# CITY OF ALBUQUERQUE

PLANNING DEPARTMENT – Development Review Services

March 21, 2016

RE: **Shoppes at Ellison (S. of La-Z-Boy)**  
**Drainage and Grading Plan | Engineer's Stamp Date 2-3-2016 (File: A14D010E)**

C1.1

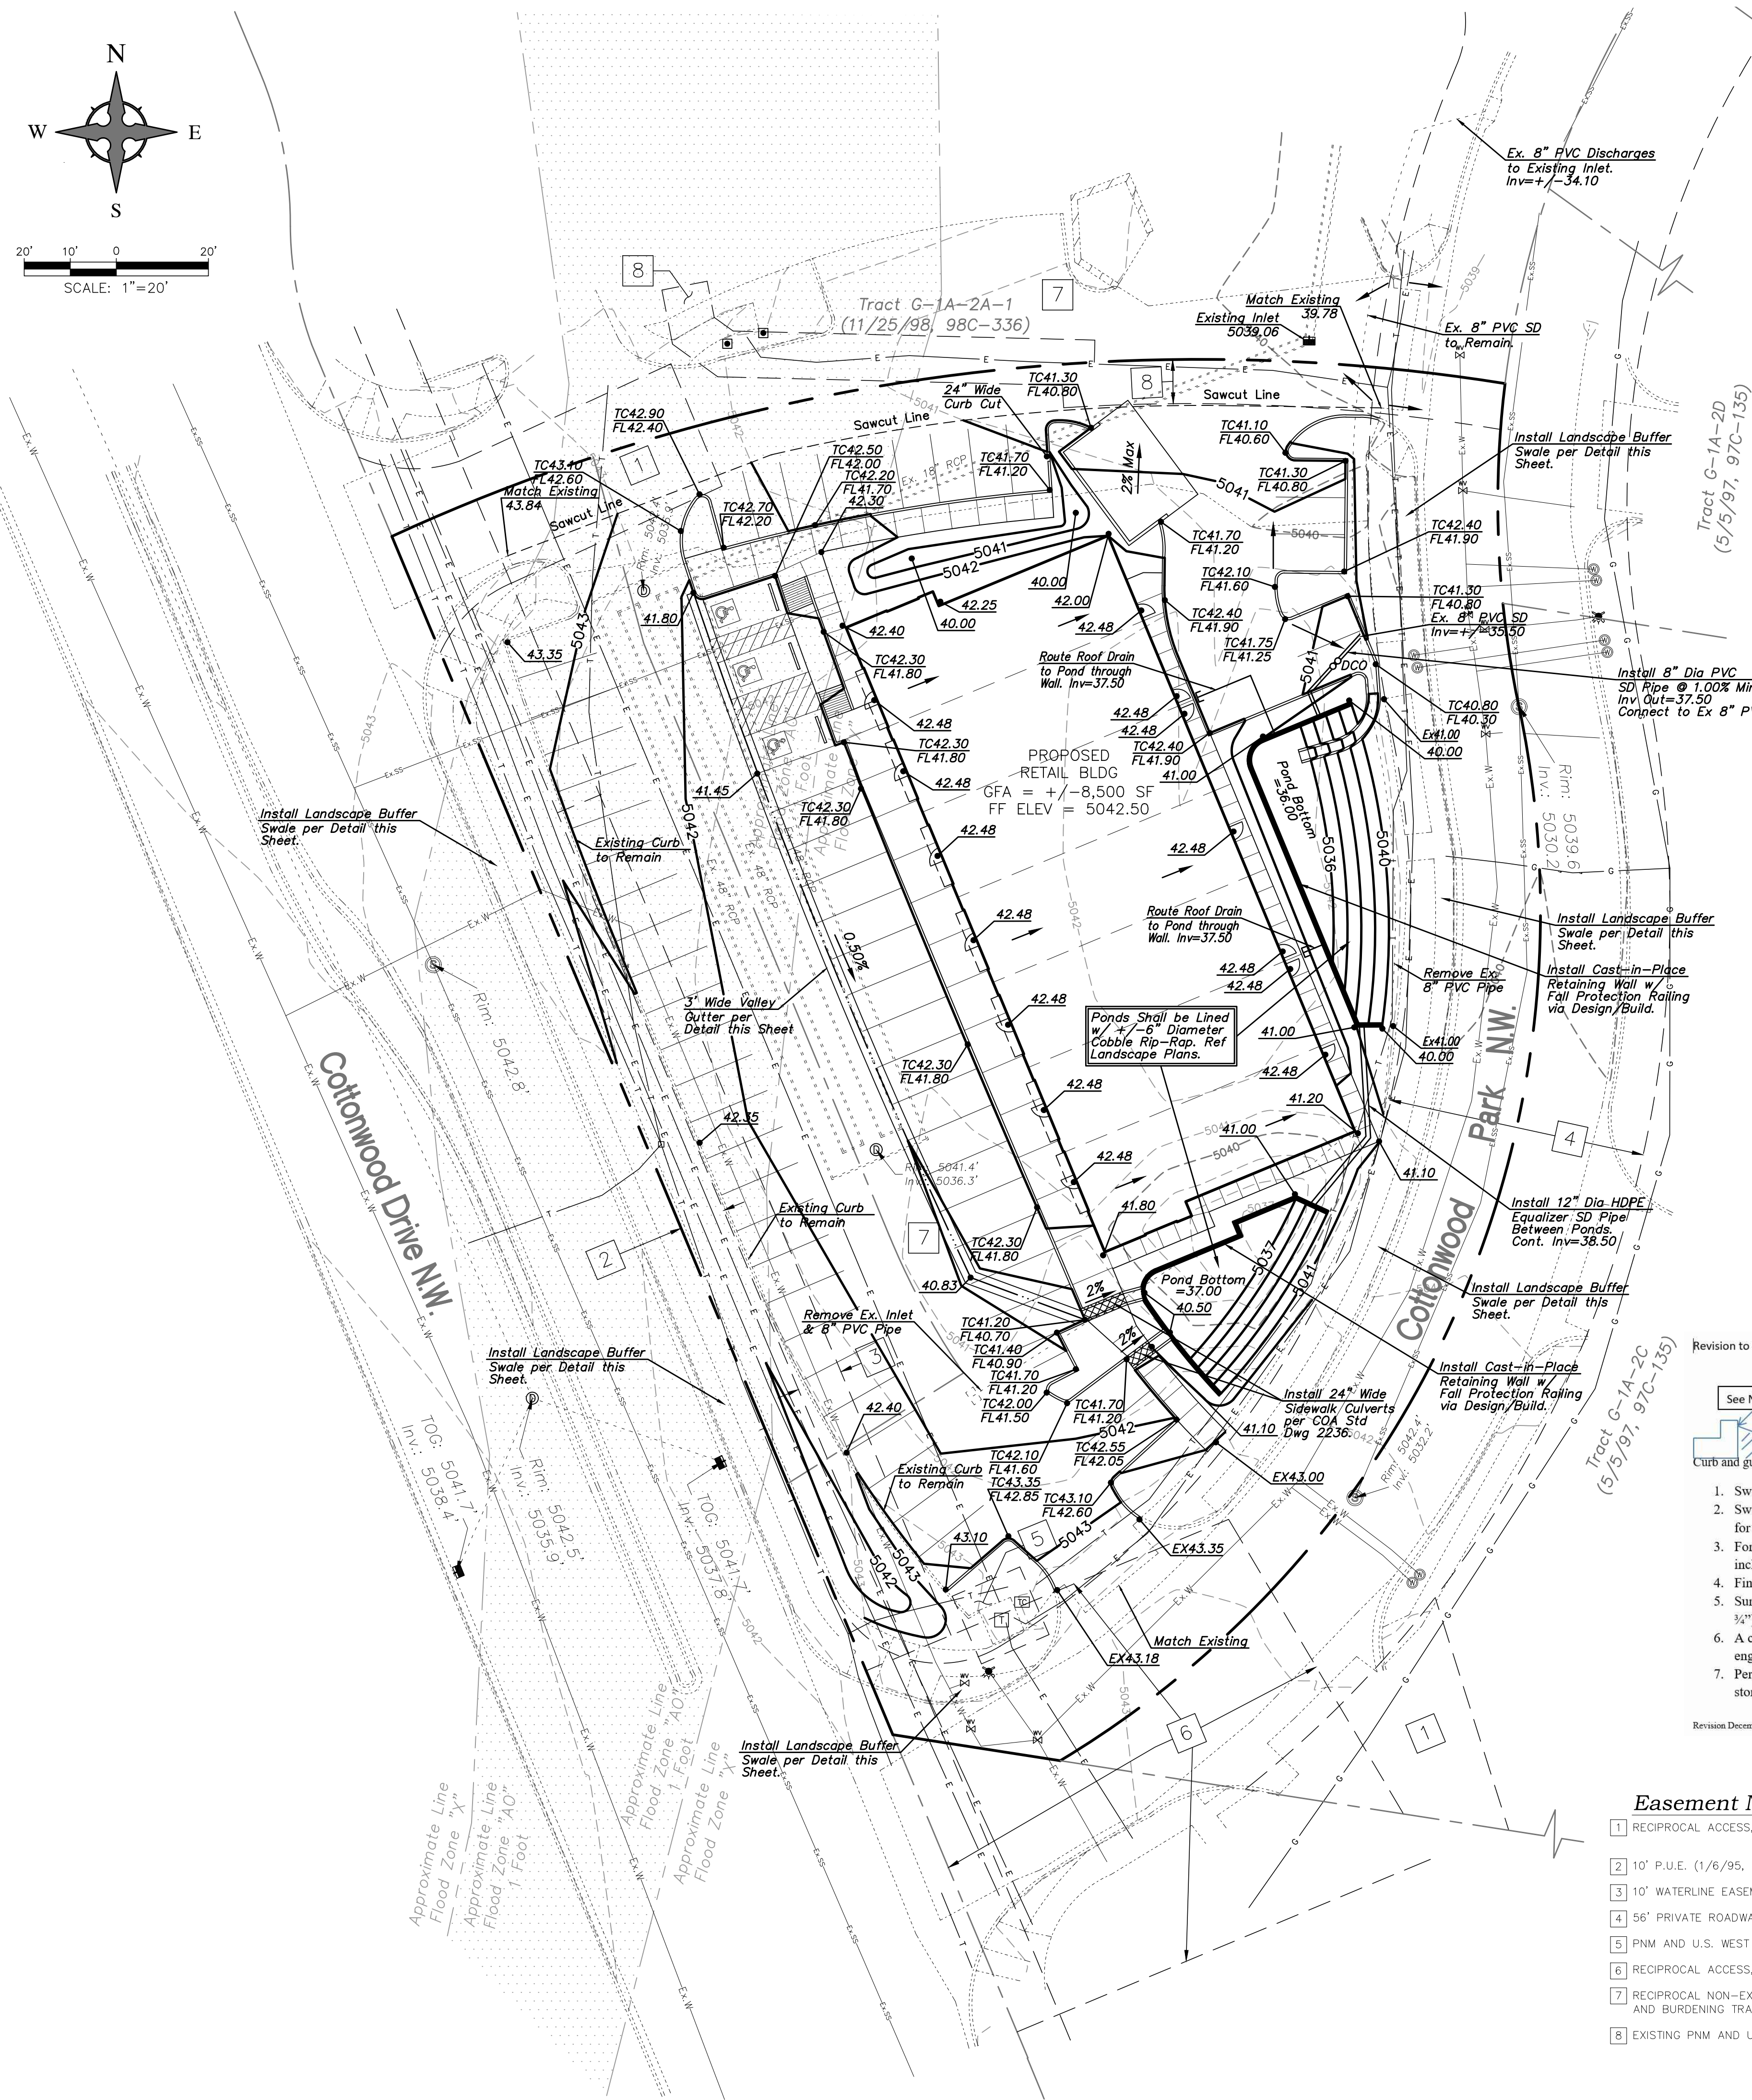
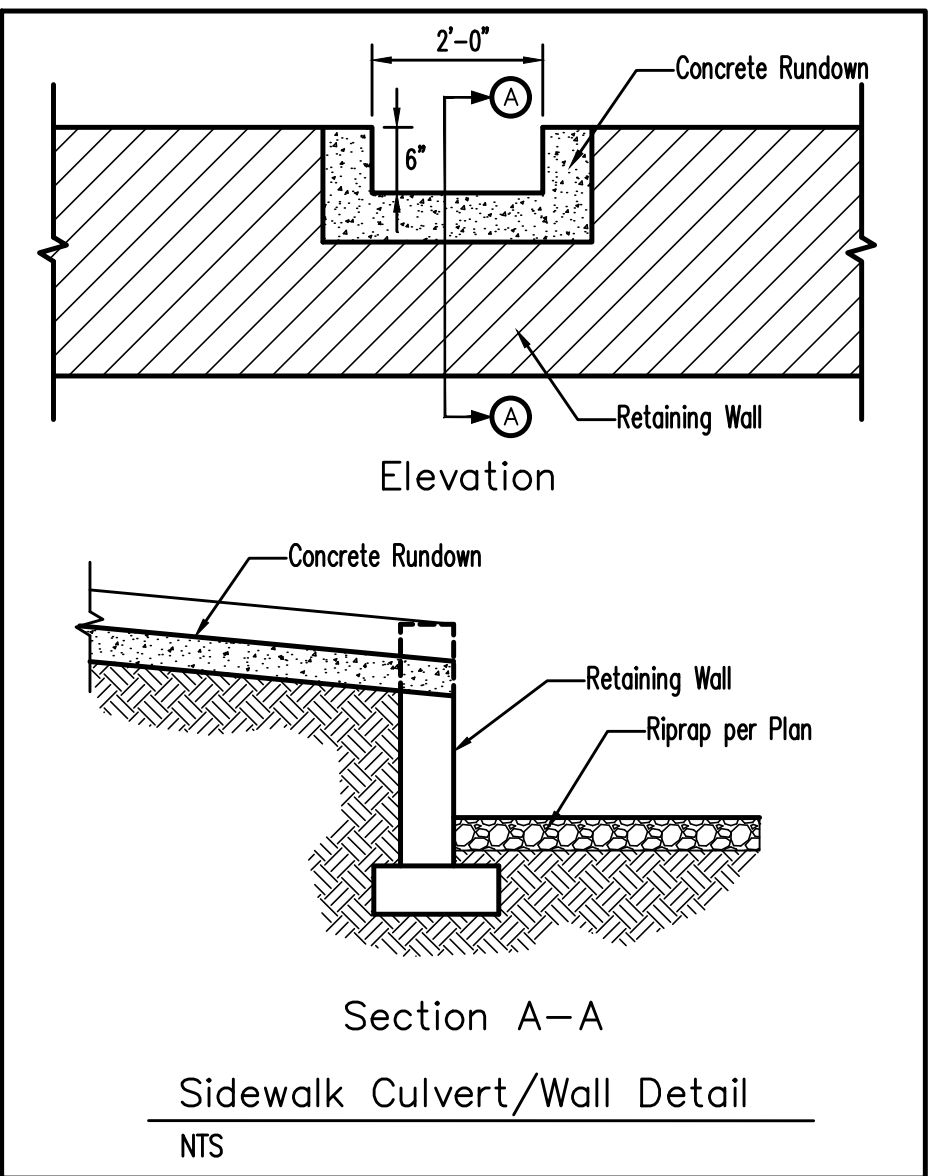
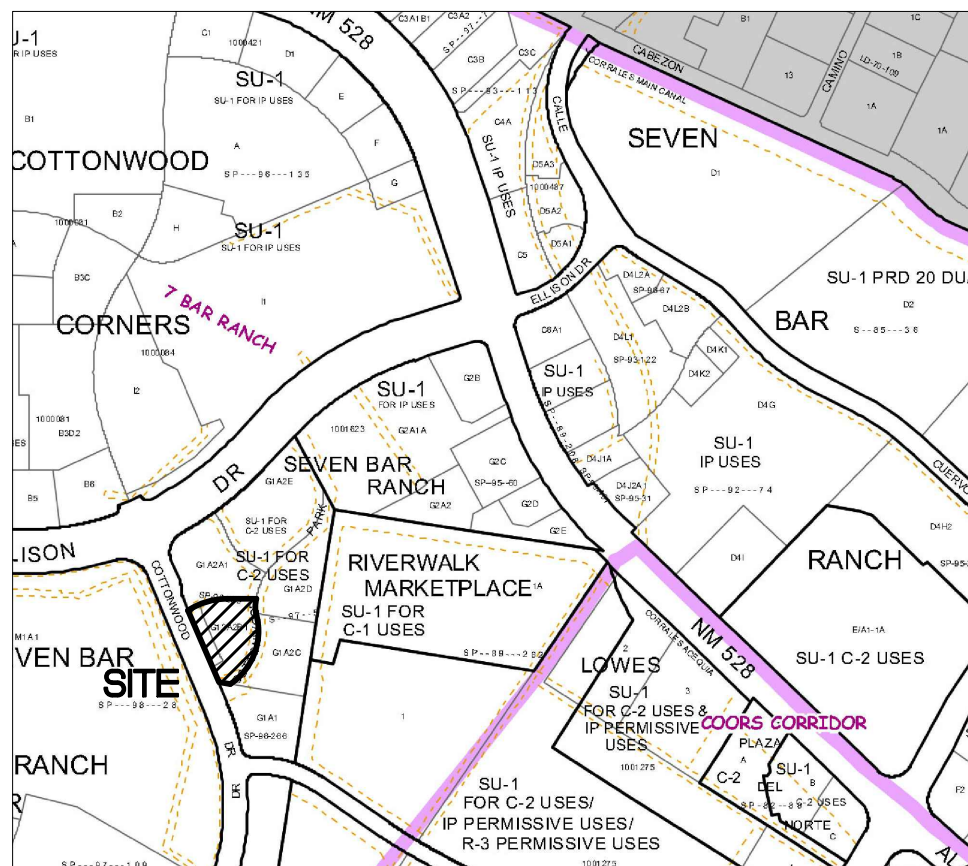
1. Provide invert elevations for the 8" equalizing within Ponds 'B' and 'C'.
2. The Drainage Report should show that the WSEL of Pond 'C' will not cause a head differential that would cause an overspill in the "La-Z-Boy" pond. The original site plan established the tops and bottoms of the two previous design iterations for this site, but it is unclear if this revised layout still complies with the Master Drainage Plan. Also, please provide excerpts and exhibits from that Master Plan, the City's file only contains poor-condition copies and scans of the correspondence for that site.

3. It appears that the buffer area between the back of sidewalk and the curb on Cottonwood Dr and Cottonwood Park will be landscaped. Please show the City's revised Standard Drawing for 2405A and 2405B to show the Landscape Buffer Swale.

4. Clarify how the sidewalk culverts in basin B drop into the pond.
5. The 8" PVC network appears to have several bends and a new connection to existing. It should be planned with cleanouts in the absence of manholes.

6. Show the intended flow direction of the roof on the plan, and location of roof drains if known. They should be routed under the sidewalk where possible.

C1.2

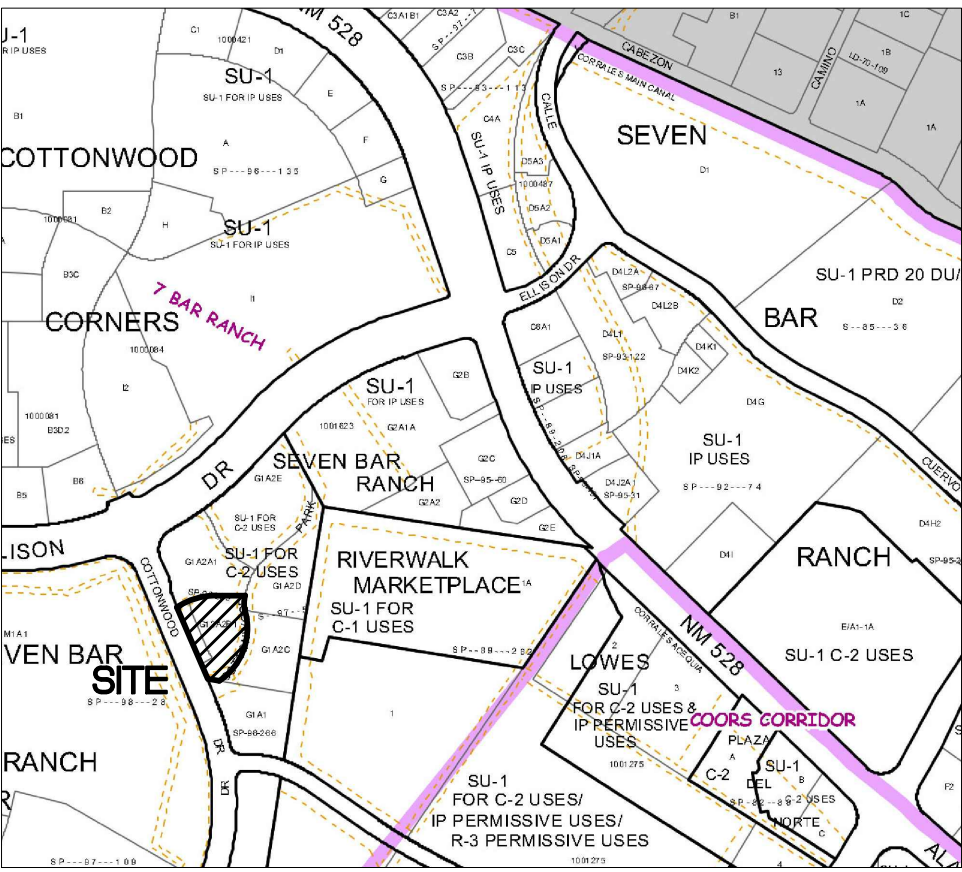
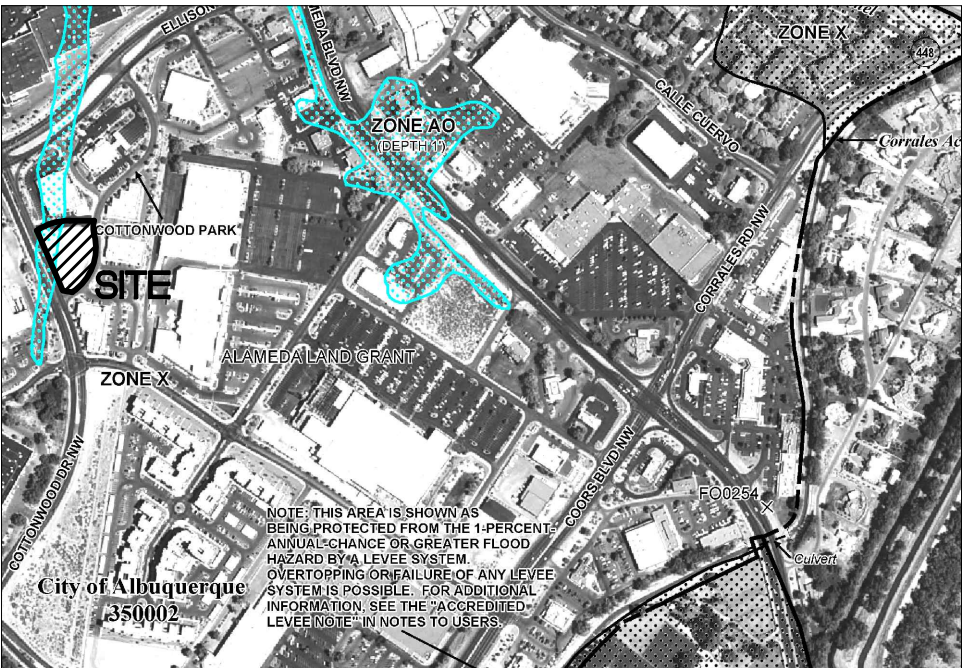
7. The first flush calculations are shown on Sheet C1.2, but it is not yet clear how Ponds 'B' and 'C' will retain the required volume.
